Rezoning Transportation Analysis

Petition Number: 2021-092

Date	Description
06-01-2021	First Review (KP)
08-23-2021	Second Review (KP)
10-22-2021	Third Review (KP)
11-22-2021	Fourth Review (KP)

SECTION E-E PEARL PARKWAY

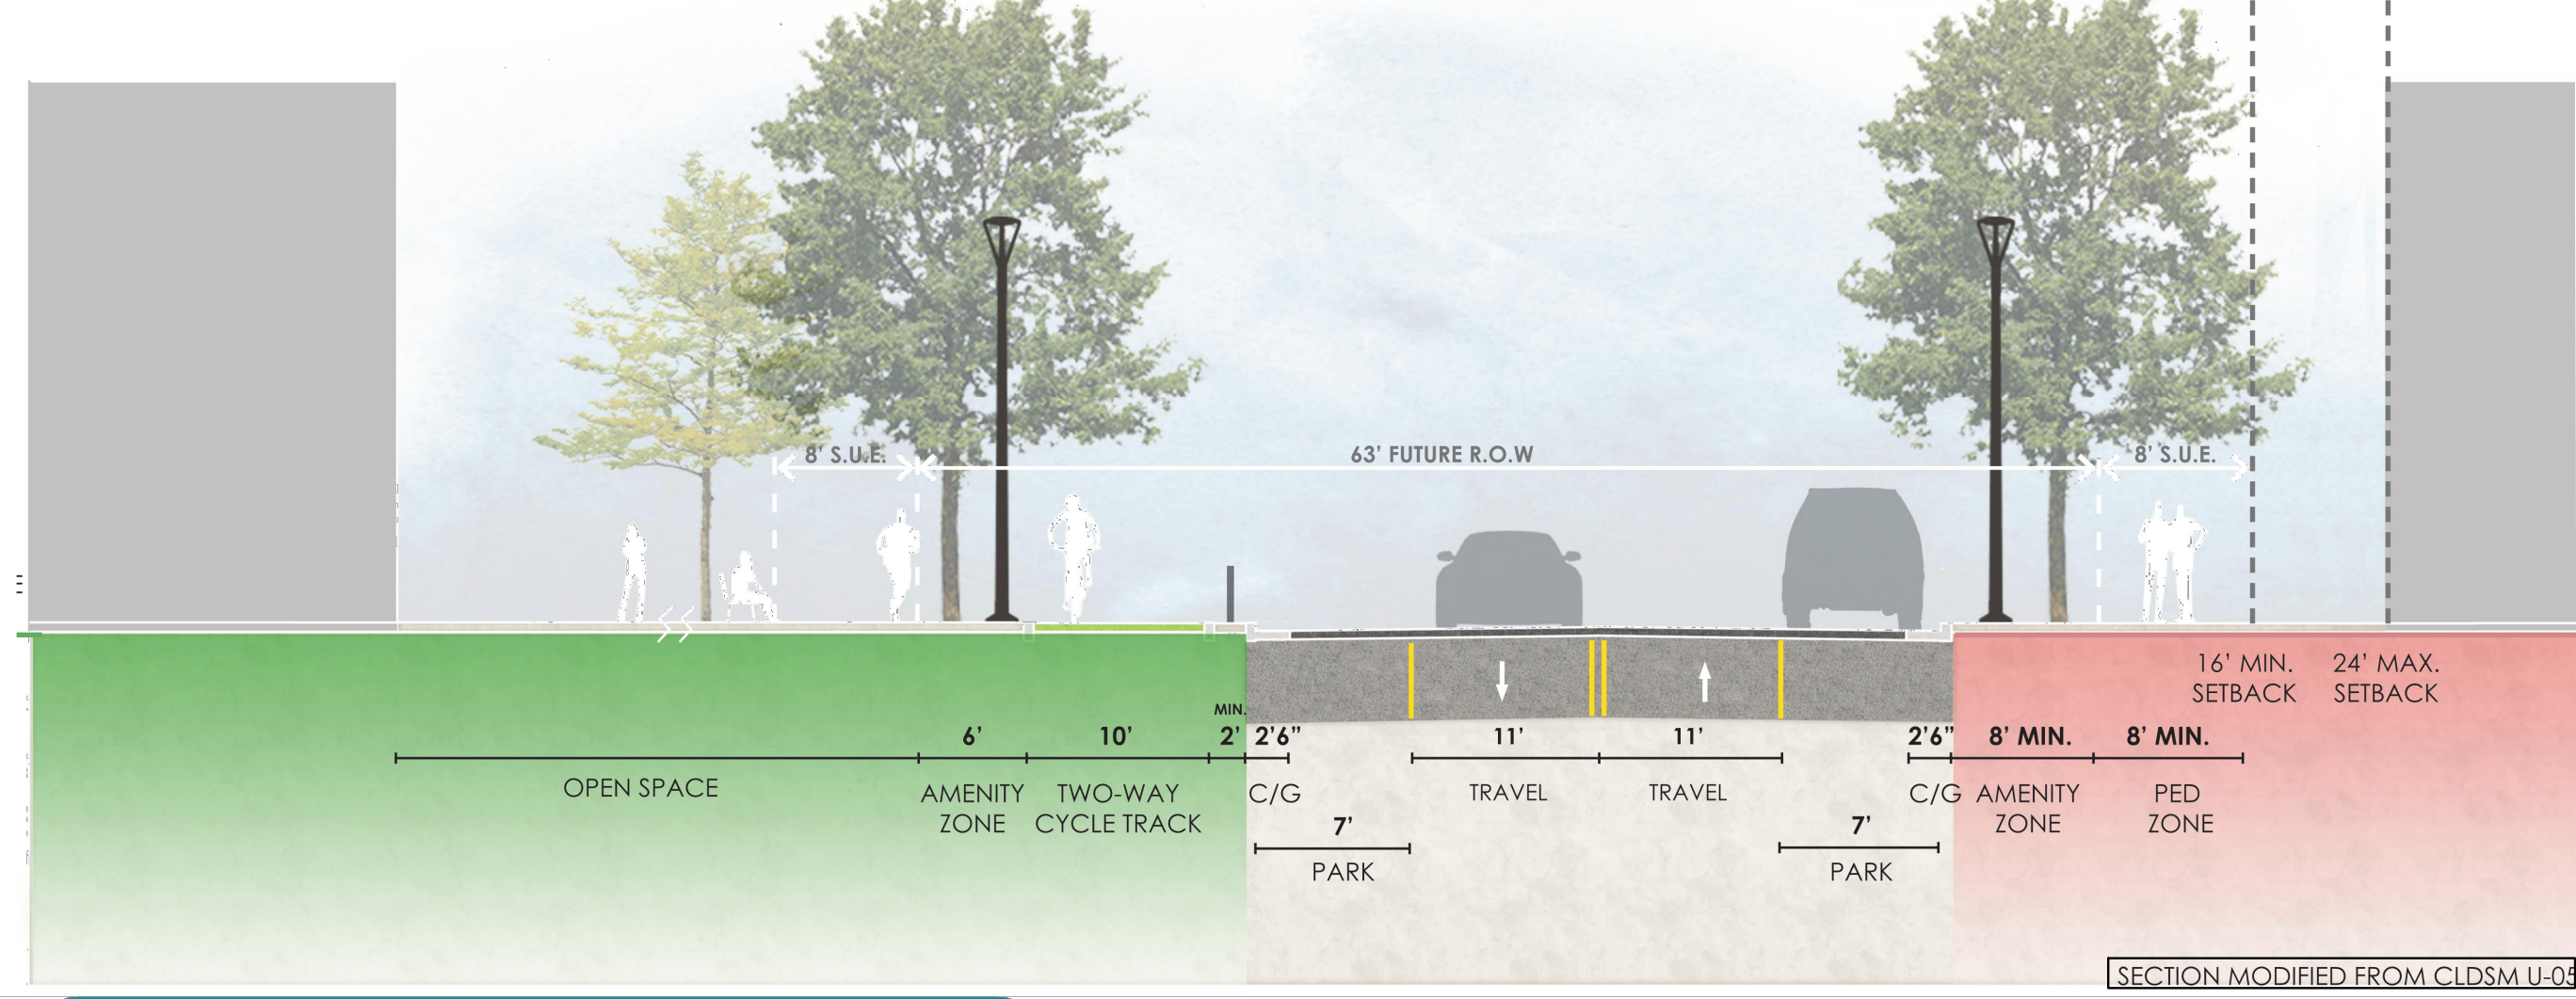
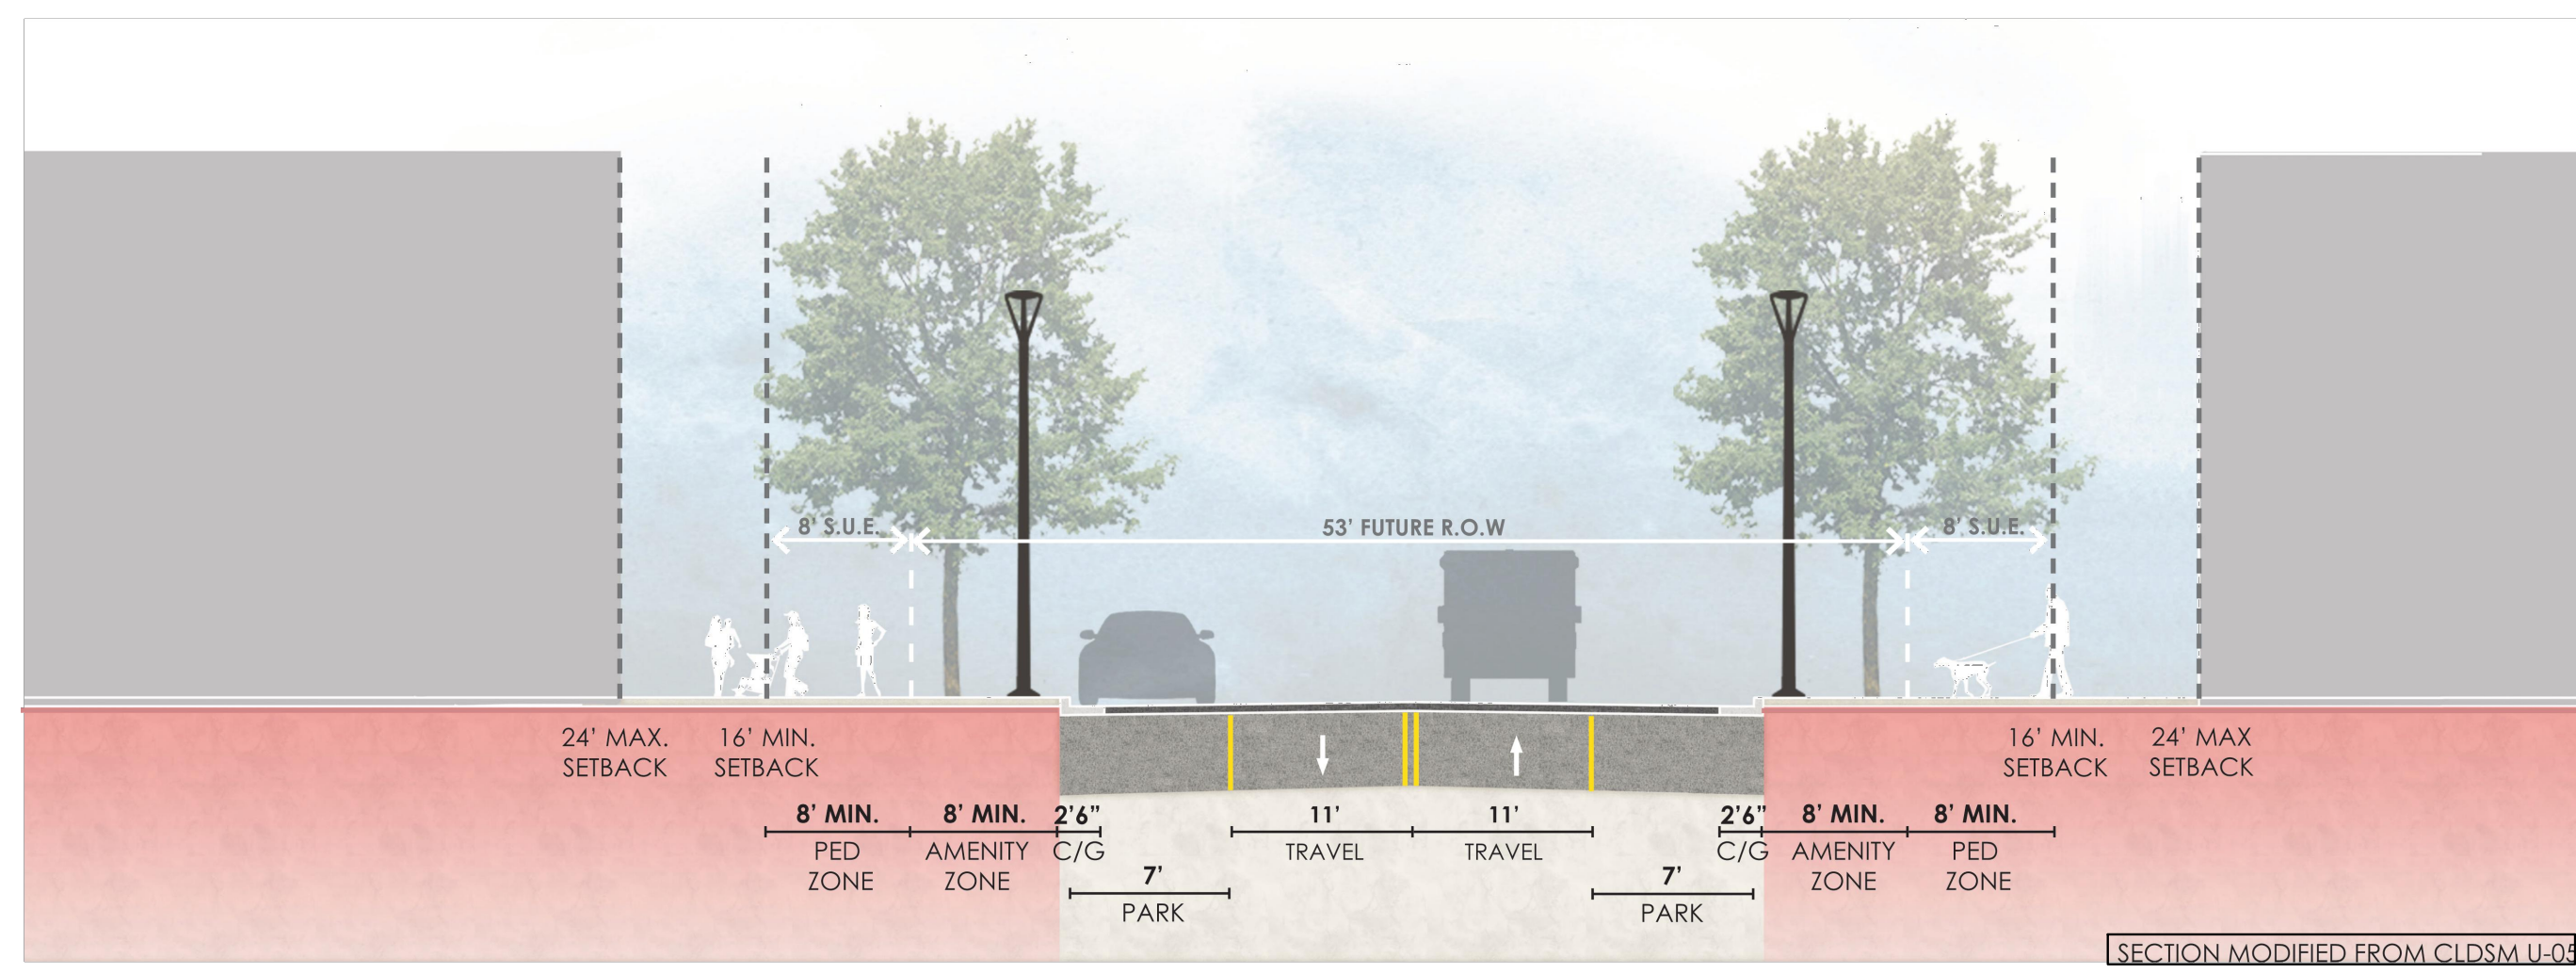
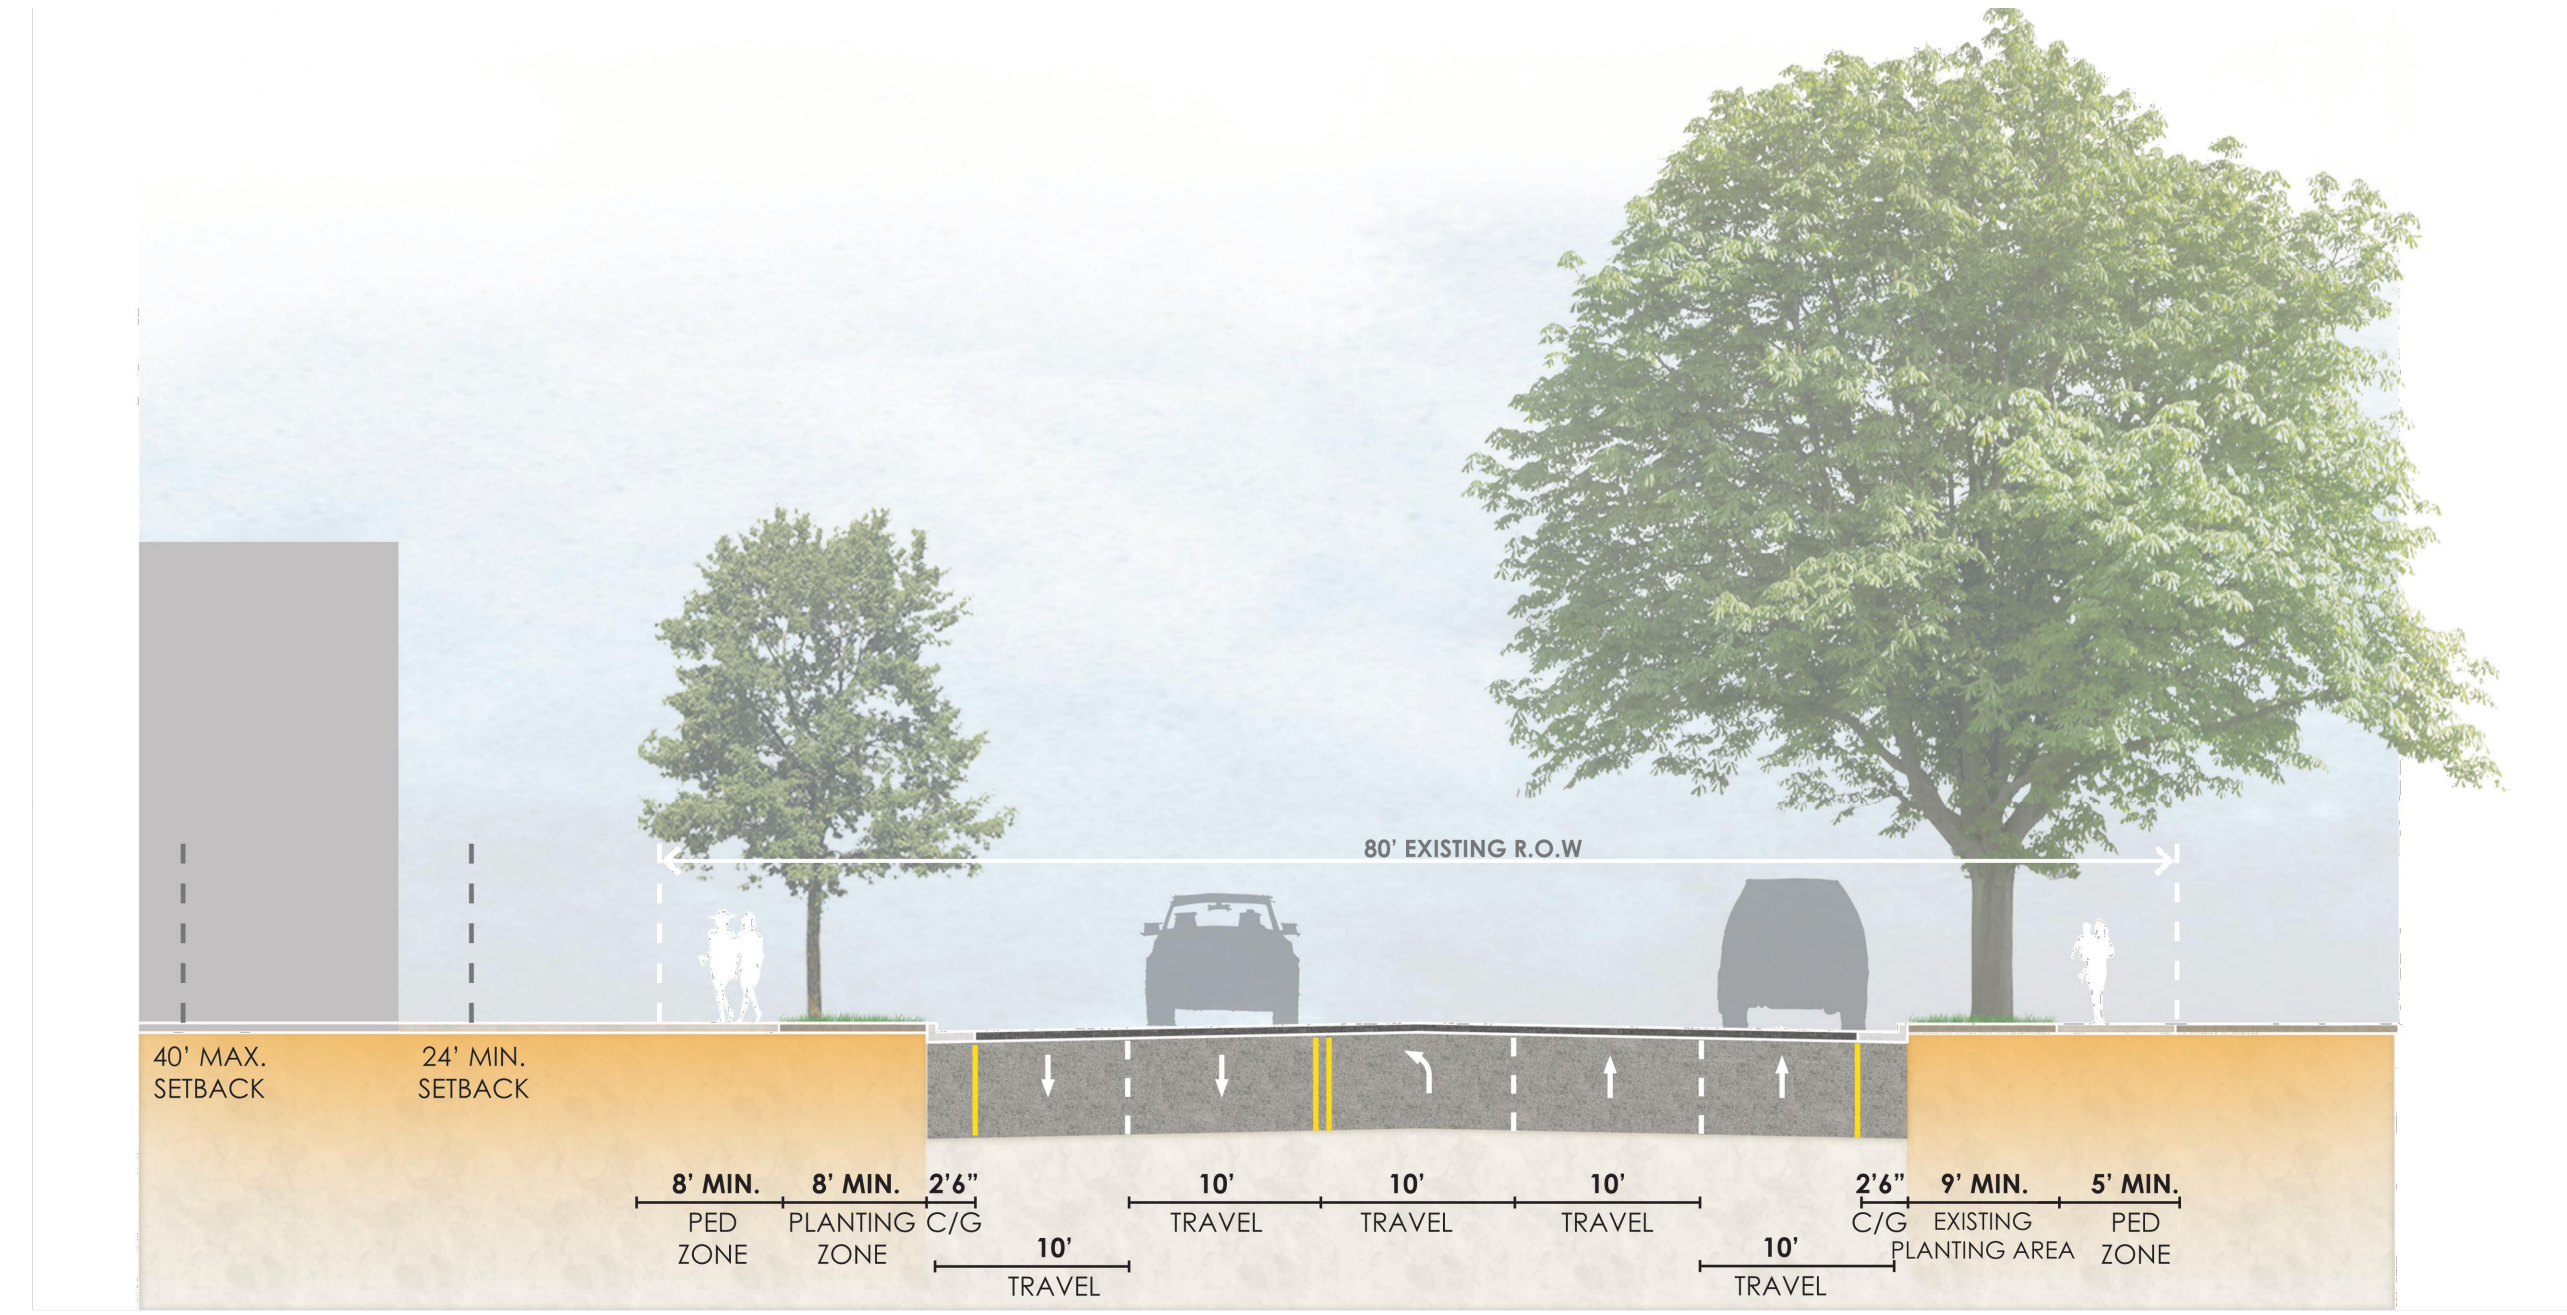
1. **Curb line:** The proposed zoning district has a setback measured from back of the existing or proposed future curb line. Revise Sheet RZ-1.1 by adding the curb line dimensions to the cross sections provided. Please note: The following curb line dimensions proposed are conceptual and may be altered as coordination with CDOT throughout the rezoning process ensues.

- a. ~~**Morehead Street:**~~ The location of curb and gutter will be moved and located 38 feet from the existing centerline to the back of curb. ~~(Revise Site Plan Dated: 10.12.21)~~ Update to comply with Chapter 20 sidewalk and planting strip requirements.

The proposed and existing back of curb location on Morehead Street must be labeled dimensioned from the existing centerline.

3. **Right of way and Other Infrastructure Dimensions:** Revise Rezoning Sheet RZ-1.1 to include detailed dimensions for each infrastructure item, and the total right of way for the cross sections shown. Refer to the USDG Cross sections and on street parking details, located within the Charlotte Land Development Standards Manual, to determine the appropriate widths associated with each infrastructure item and the cross sections' total widths. Revise the site plan sheets by clearly labeling each public and private street section as well as each access point. Labeling each street section and access point will allow for thorough comments throughout the rezoning and permitting process. CDOT prefers the separated cycle track and sidewalk for McDowell Street (cross sections A-A and B-B). Please note: The following right of way dimensions proposed are conceptual and may be altered as coordination with CDOT throughout the rezoning process ensues:

- a. ~~**Morehead Street: (10/21/2021 Site Plan)**~~ – 56 feet of right of way dedication measured from the existing road centerline.
- b. ~~**McDowell Street:**~~ 110 feet of total right of way dedication, 55 feet measured from the existing road centerline to each right of way line.

The proposed and existing Morehead Street right of way dedication must be labeled dimensioned from the existing centerline. ~~**Outstanding comment (10/21/2021 Site Plan)**~~ – Revise the site plan conditional notes and legends that all new streets shall be determined as public or private during permitting. Revise cycle track along McDowell Street to include a sidewalk utility easement, where appropriate.
